From: Contact Centre (CRM) <contact@ribblevalley.gov.uk>
Sent: 08 February 2024 11:15
To: Planning
Subject: Planning Application Comments - 3/2023/0866 FS-Case-585087571

Planning Application Reference No.: 3/2023/0866

Address of Development: 11 Old Road, Chatburn

Proposed Site Plan 1:200

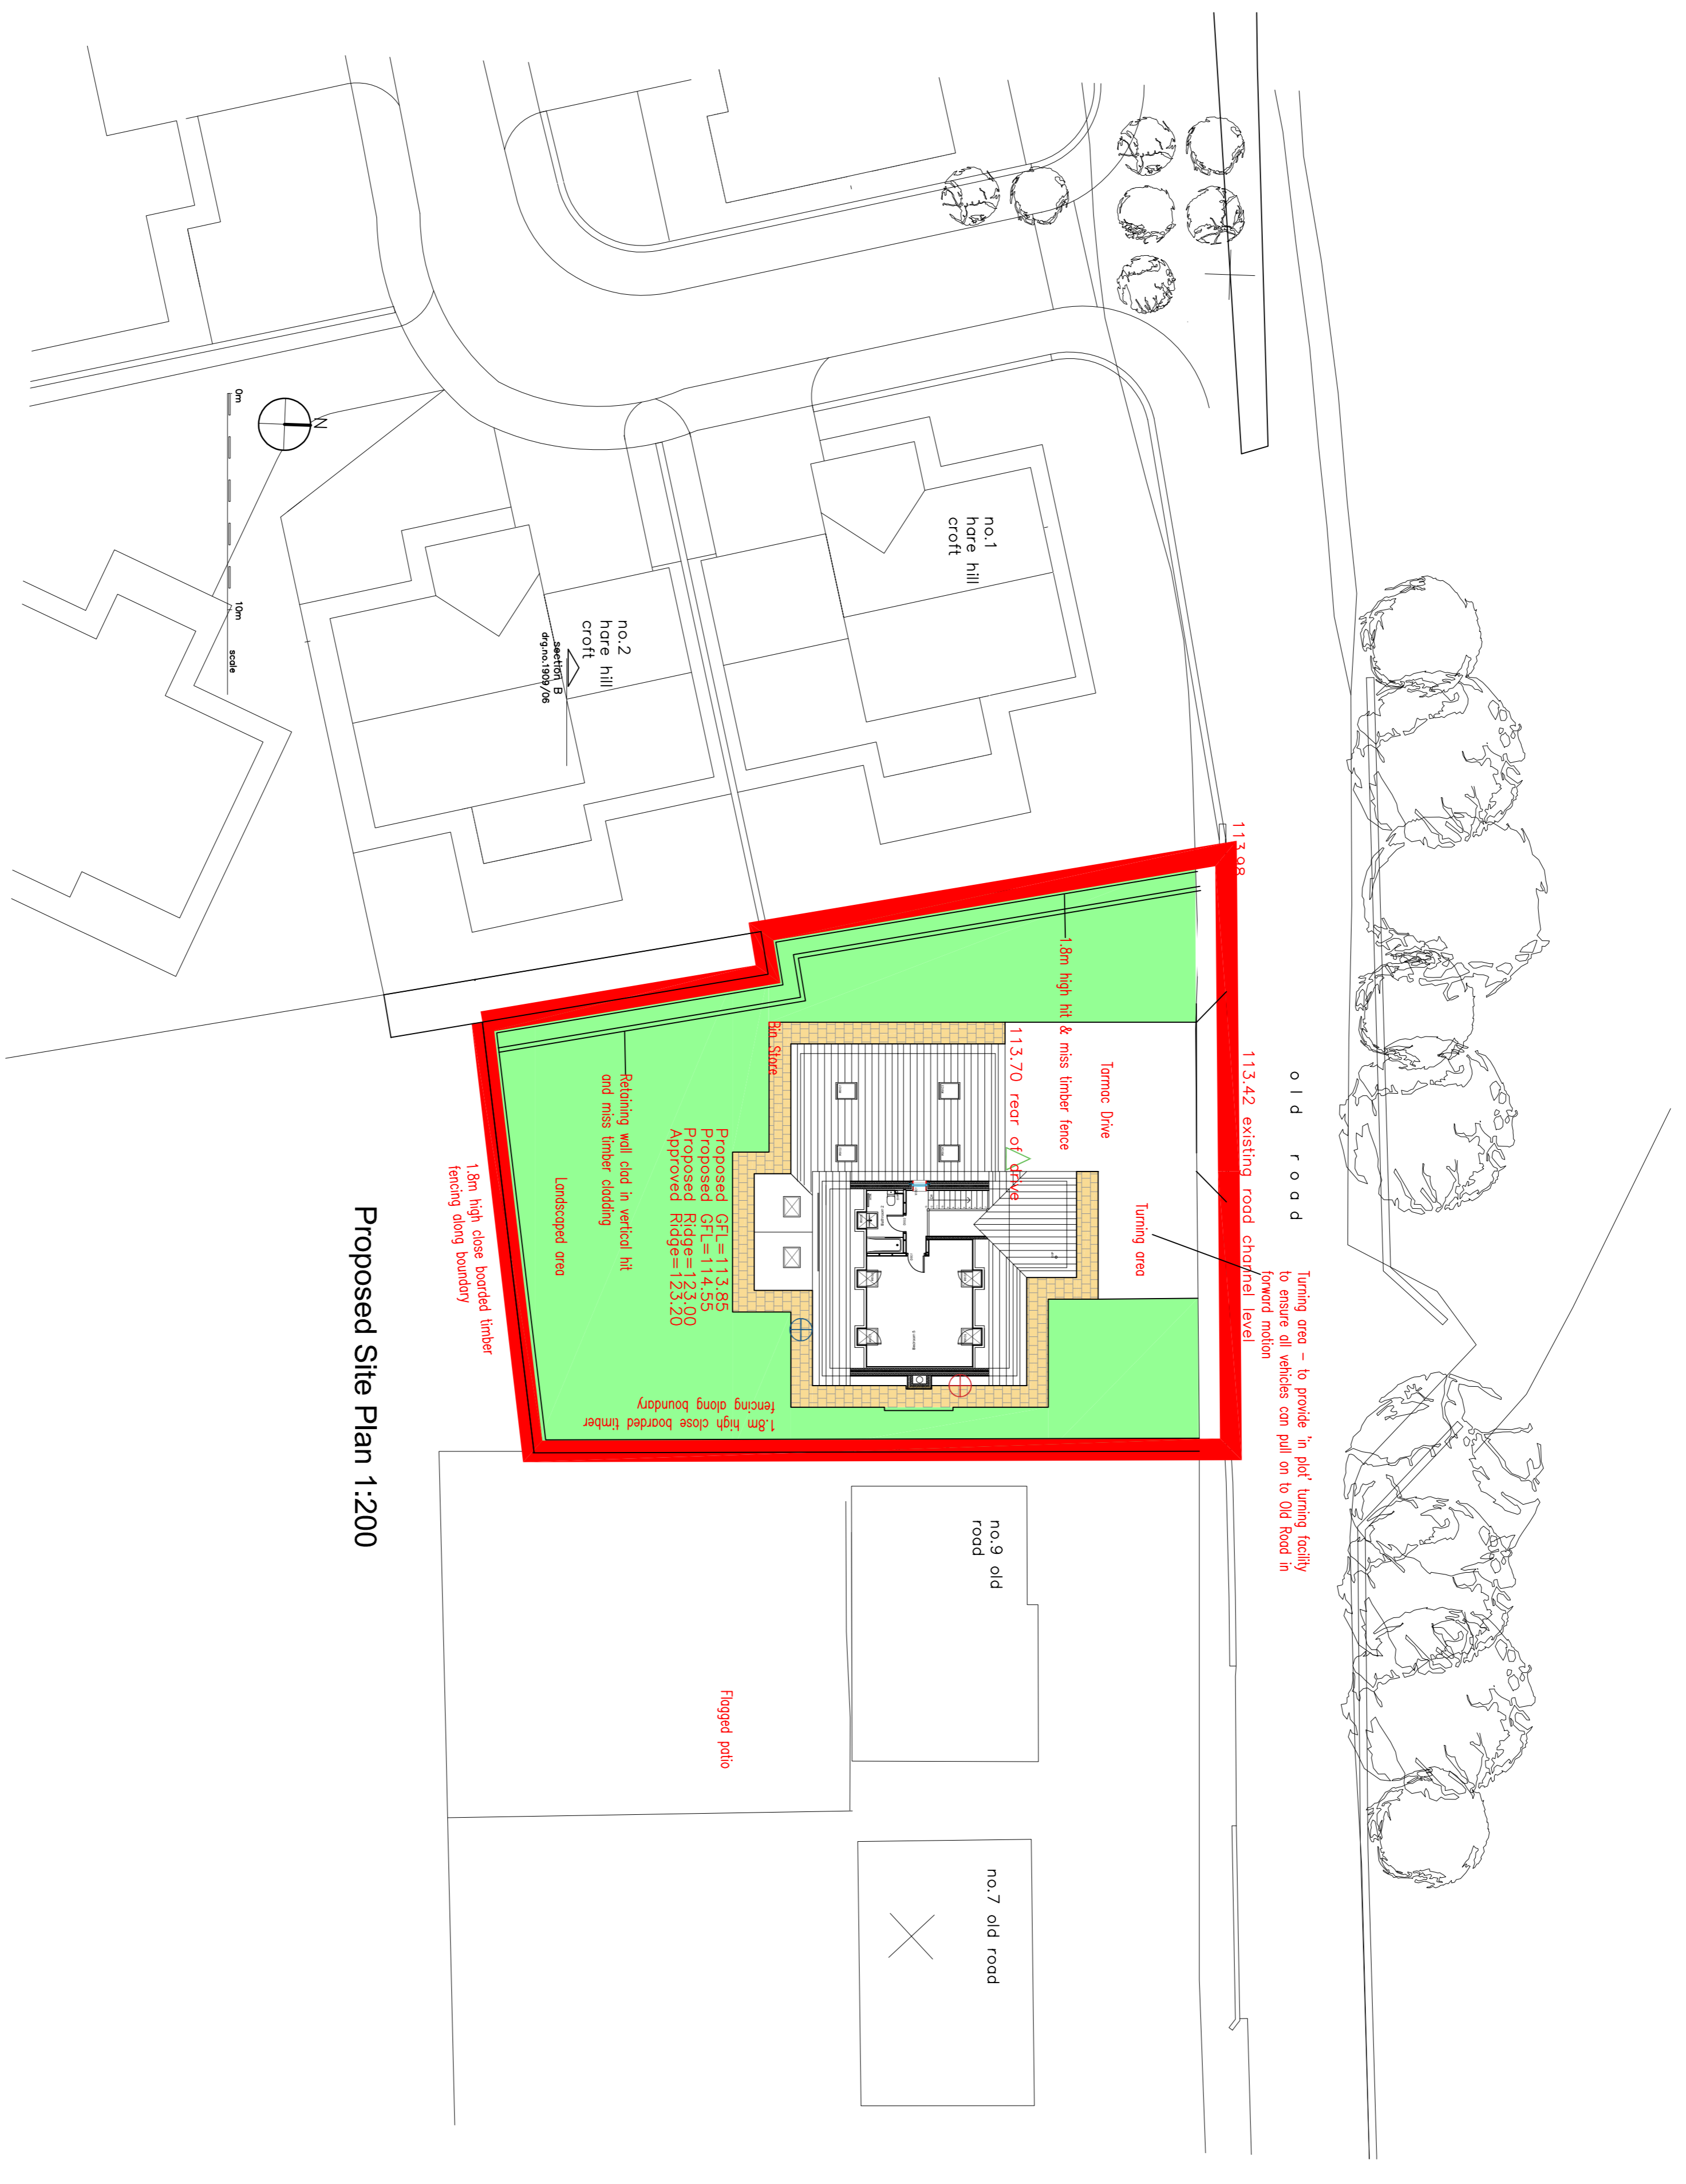
Comments: In the comments from LCC Highways, it states that "The LHA remind the Agent/ Applicant that a 4 bed dwelling should provide a minimum of 3 car parking spaces to comply with the LHAs Joint Lancashire Structure Plan". However on the plan of the house there is only room for 2 cars, as the other possible location is designated as a turning area. Its impossible to park 3 cars AND maintain the ability to turn, so that vehicles can exit forwards, as demanded for this class of road.

Drawing Title
Sections

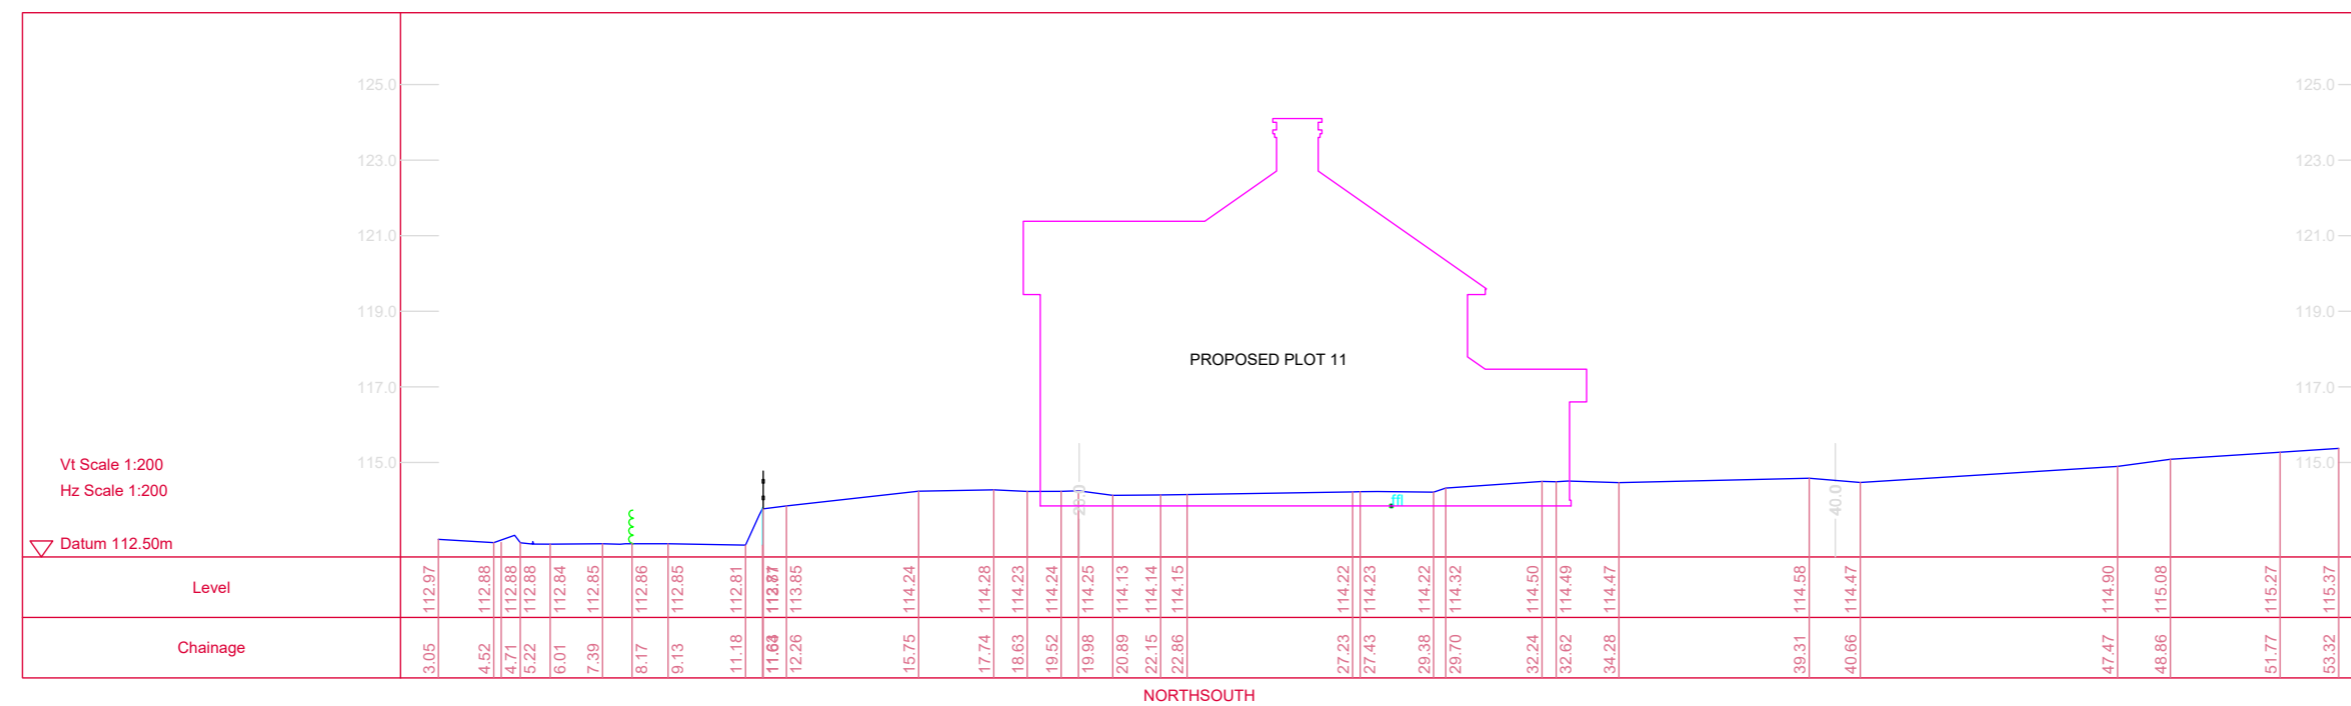
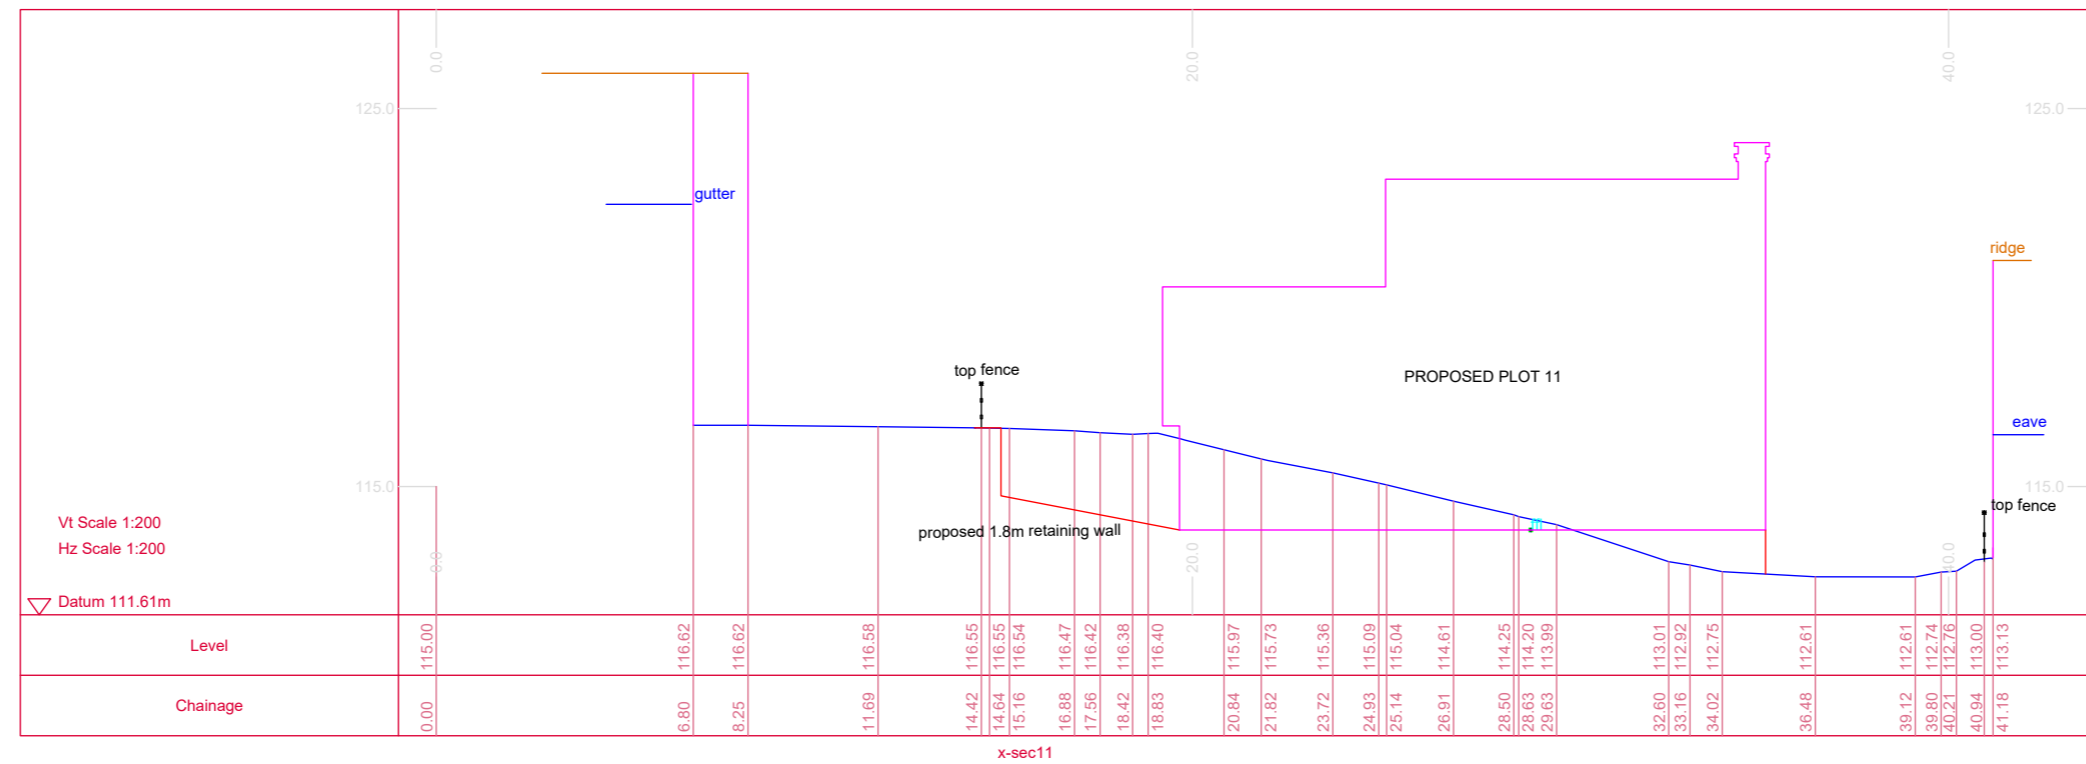
Comments: It is becoming increasingly difficult to make valid objections, because the applicant keeps adding and amending plans, that superseded or in some cases conflict with current documents. We residents have a limited time to comment, but the applicant is not providing sufficient detail such as retaining structures and section details to allow us to make reasonable objections.
